From: Graham Middle [clocktowerhouse@btconnect.com]
Sent: 25 January 2012 15:50
To: Anita Gardner
Subject: RE: CL/11/11/DOC - Compliance with condition 6 of CL/11/10
Attachments: SITE PLAN SP01B Model (1).pdf

Waterford House (formerly Merrie Gardens), Clapham, Worthing, West Sussex, BN13 3UY
Planning Application : CL/11/10

Waterford House (formerly Merrie Gardens), Clapham. Worthing, West Sussex, BN13 3UY
Planning Application : CL/11/10

Waterford House (formerly Merrie Gardens), Clapham. Worthing, West Sussex, BN13 3UY

AMENDMENT 'A' : August 2011
ADD: Boundary Tree Planting Information - GRM

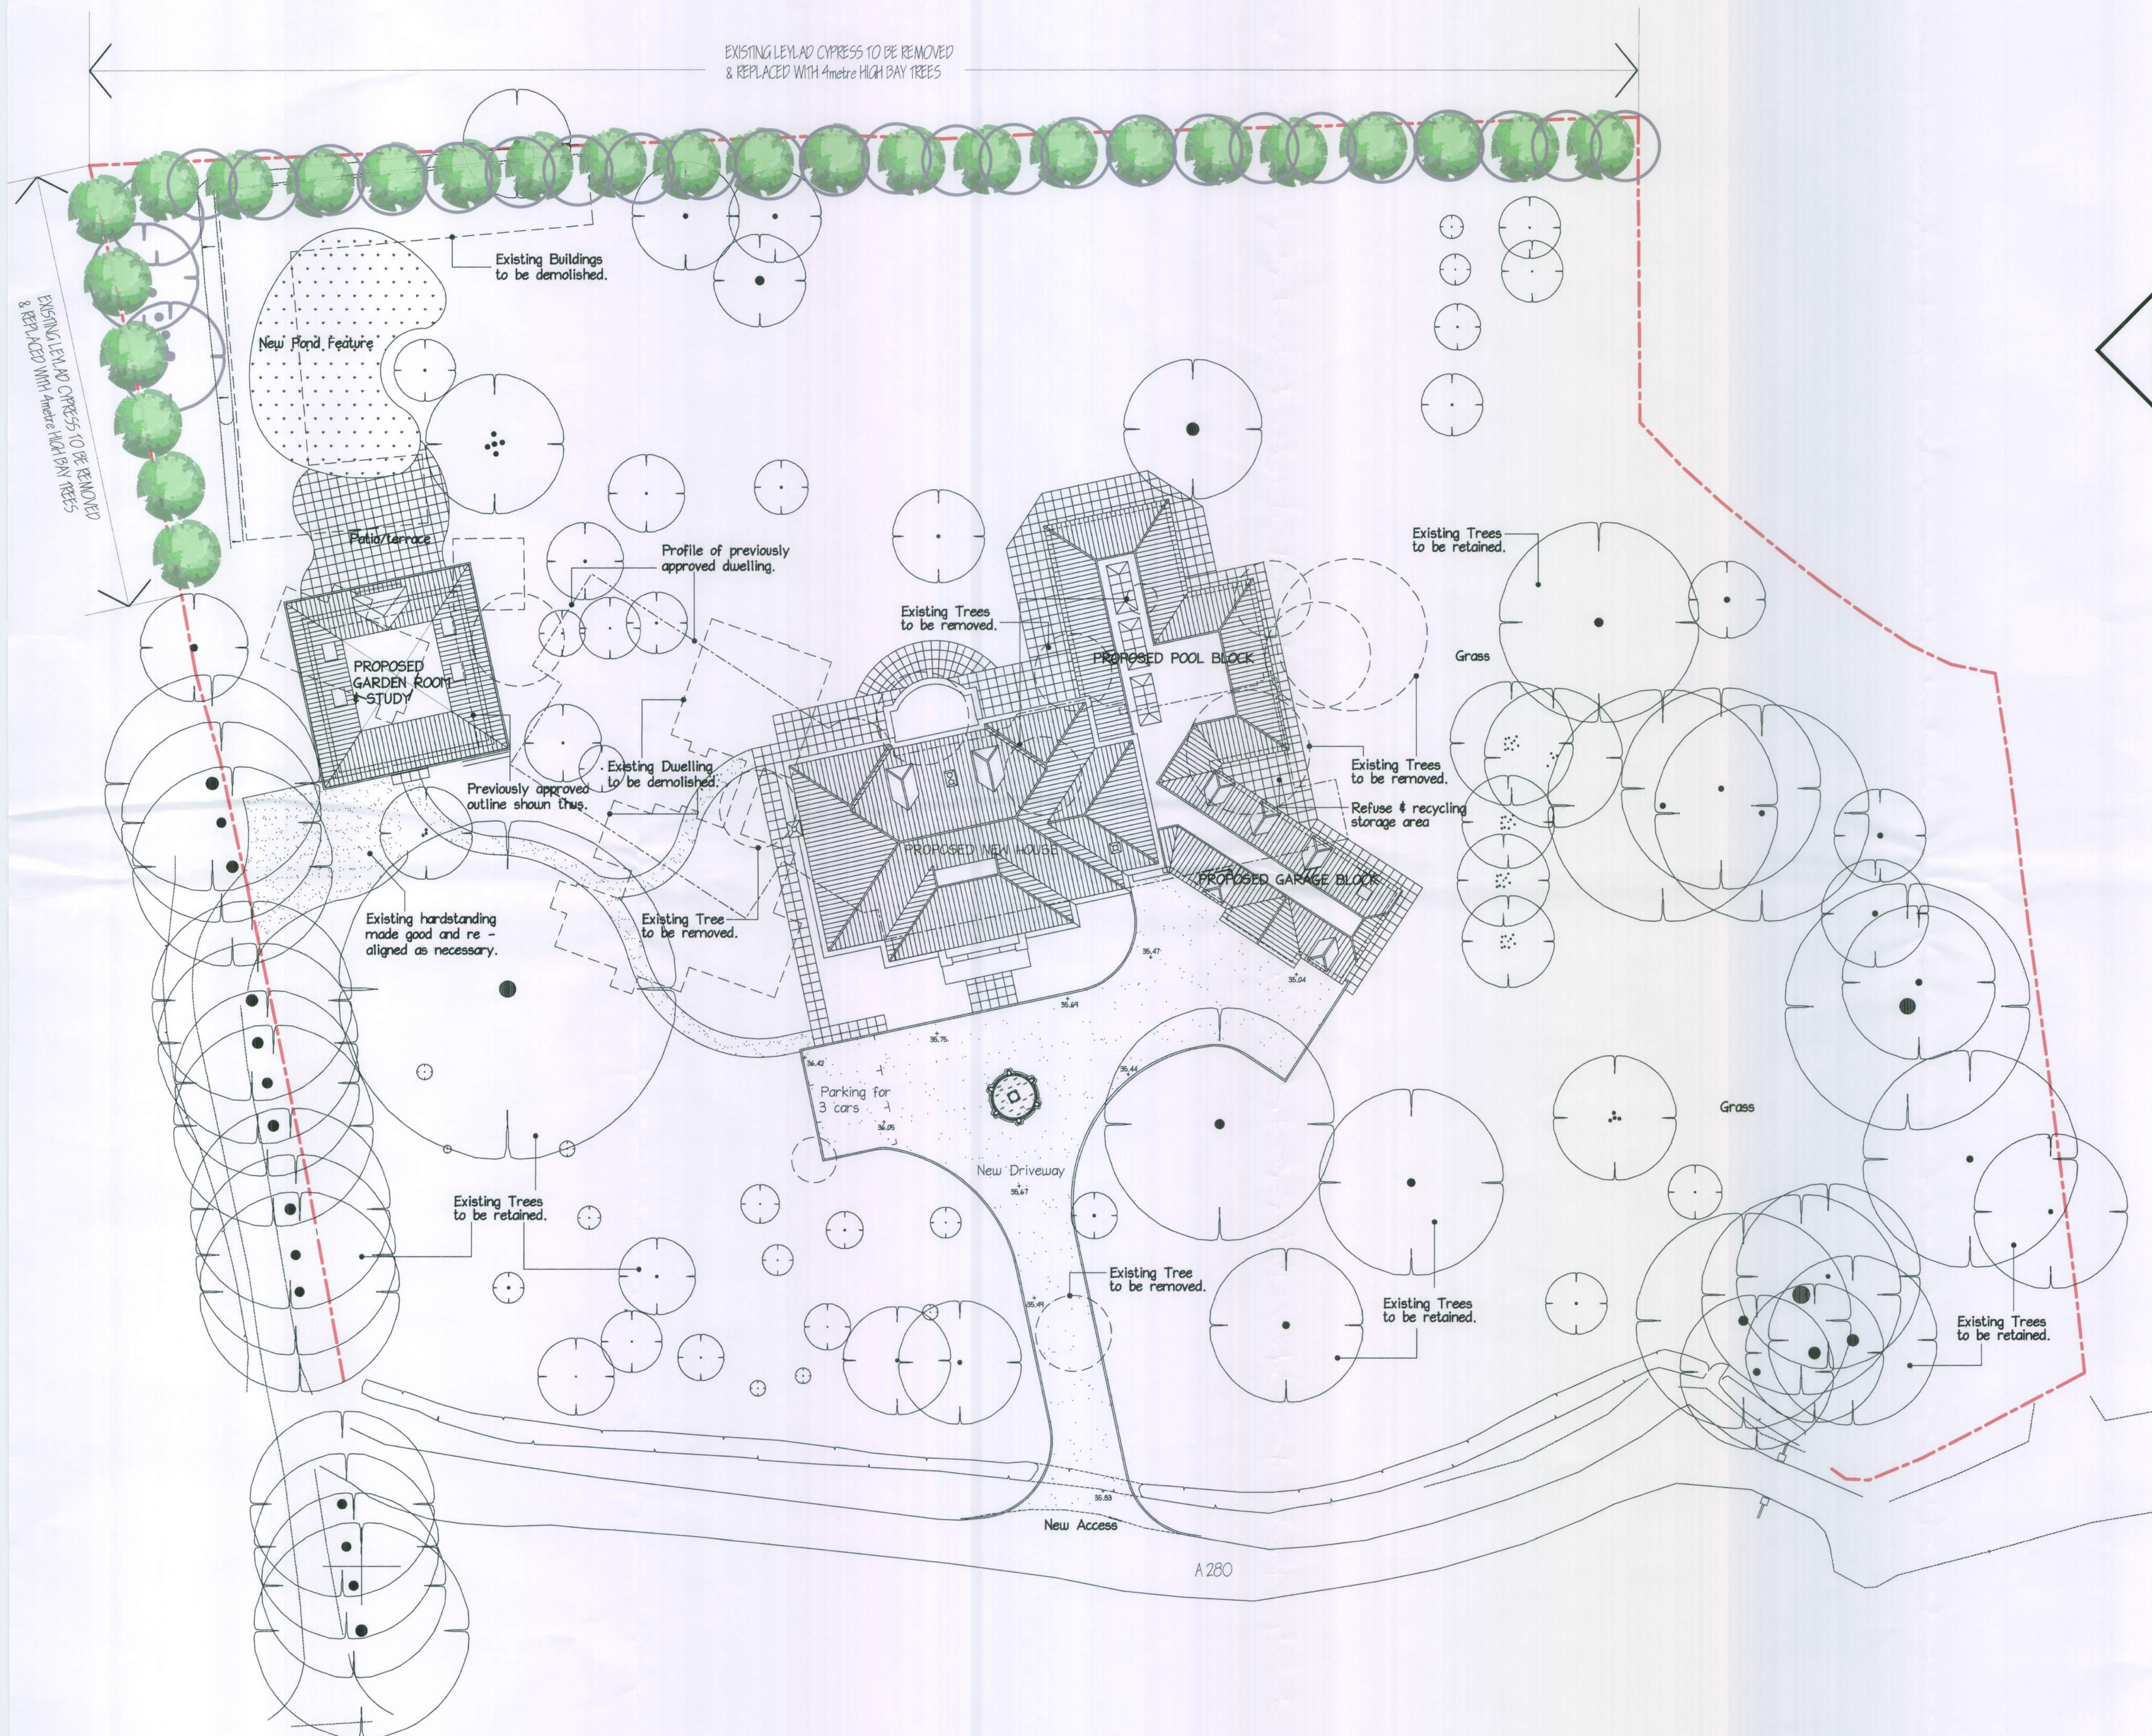
I am still in the process of liaising with the Tree Officer regarding compliance with the above condition. I note that drawing no 0311/SP01 A does not include the most southerly portion of the site and therefore does not confirm the position of Root Protection in this area. Also the Tree Protection Area relating to G6 does not accord with the trees indicated for retention on drawing 0311/SP01 revA, and the trees to be retained in the southeast corner of the site are not referred to or indicated on the Protection Plan. Please could you let me have an amended Tree Protection Plan relating to the whole of the application site approved under CL/11/10 and include all trees previously identified to be retained throughout the course of development.

I am still in the process of liaising with the Tree Officer regarding compliance with the above condition. I note that drawing no 0311/SP01 A does not include the most southerly portion of the site and therefore does not confirm the position of Root Protection in this area. Also the Tree Protection Area relating to G6 does not accord with the trees indicated for retention on drawing 0311/SP01 revA. and the trees to be retained in the southeast corner of the site are not referred to or indicated on the Protection Plan. Please could you let me have an amended Tree Protection Plan relating to the whole of the application site approved under CL/11/10 and include all trees previously identified to be retained throughout the course of development.

I have adjusted dwg. SP01A to match Arbtech's TPP drawing, however I cannot get hold of Mike Hartnett and none of the original Architects drawings in our possession clarify the land, trees or boundary line to the West of the drive, but can confirm the landscape works to this area have been completed.

Please advise how you wish me to progress or is the attached amended drawing SP01B acceptable?

Arboricultural Supervision

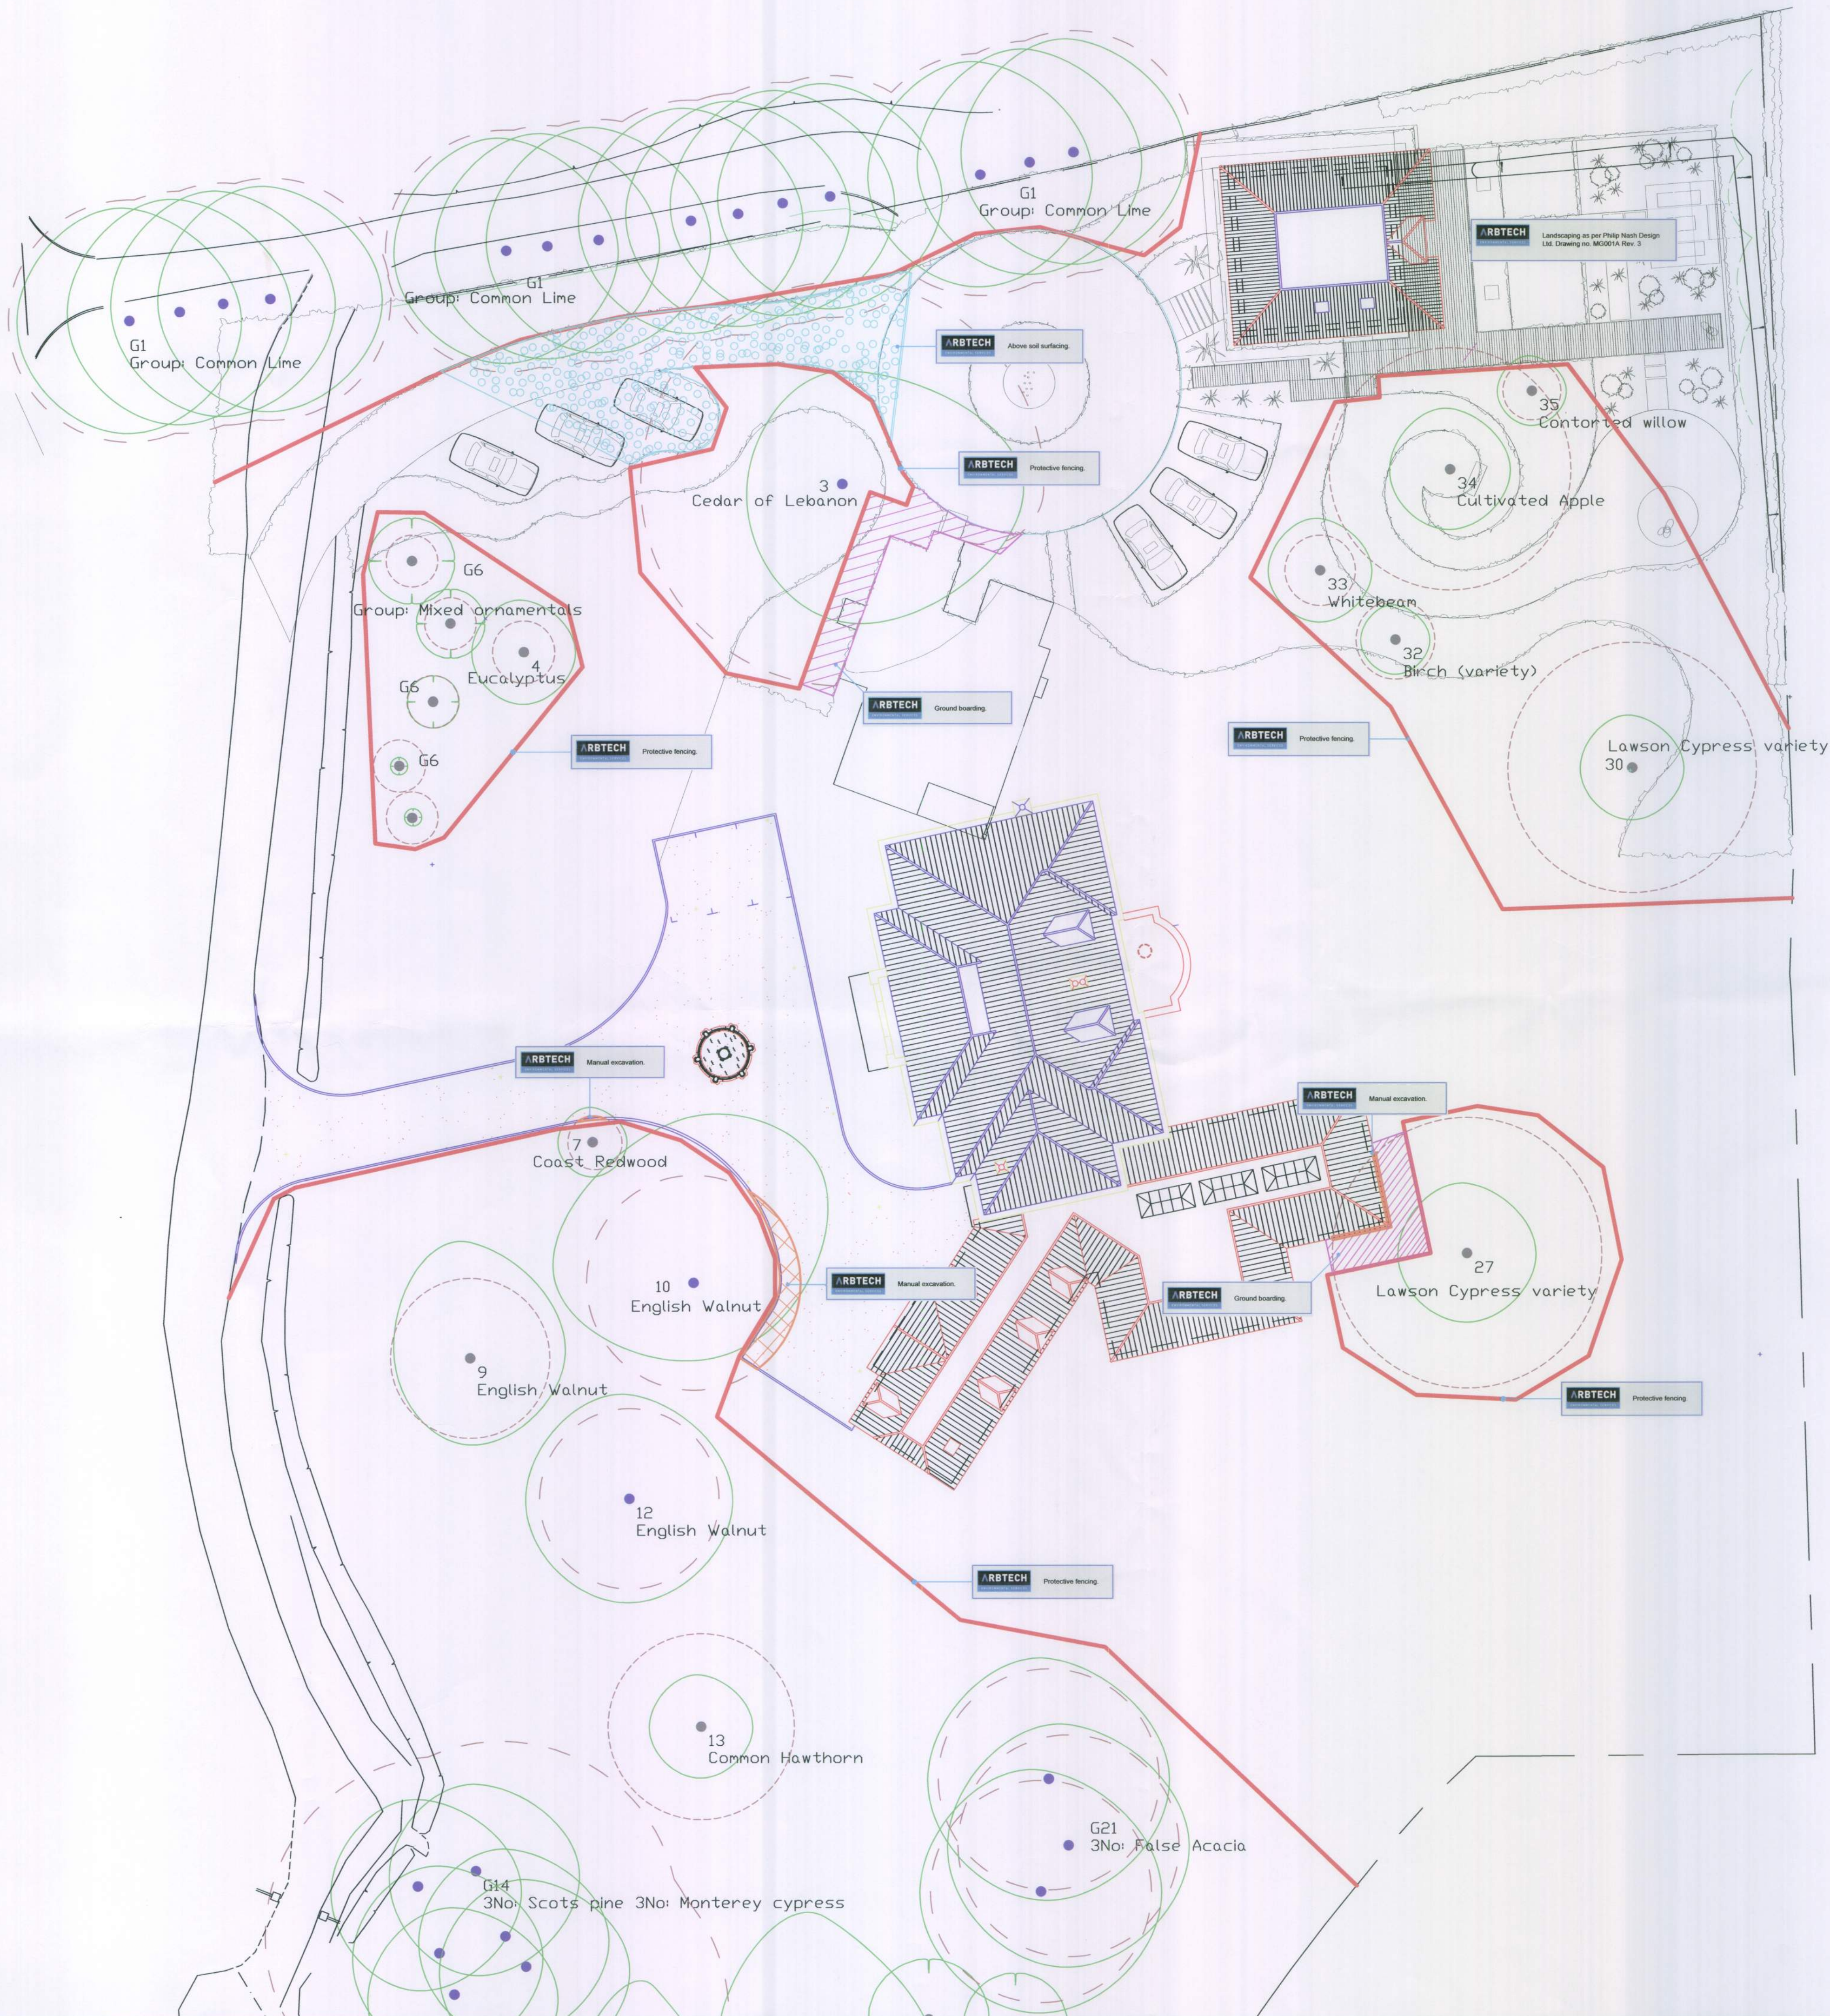
I refer to our earlier conversation with regard to the difference between dwg. SP01A & Arbtech's TPP drawing relating to existing/to be retained trees, together with both drawings not providing any information relating to the land within the site boundary located to the West of the existing drive which you advised formed part of the original planning application.

Further, I would advise that the Tree Officer visited the site last Friday and noted that soil was being piled up on top of tree roots within the Root Protection Areas and that heavy machinery has been driven across these areas. I would therefore request that in the interests of the long term retention and health of the trees these undertakings cease and steps are taken to remove the soil if this has occurred recently.
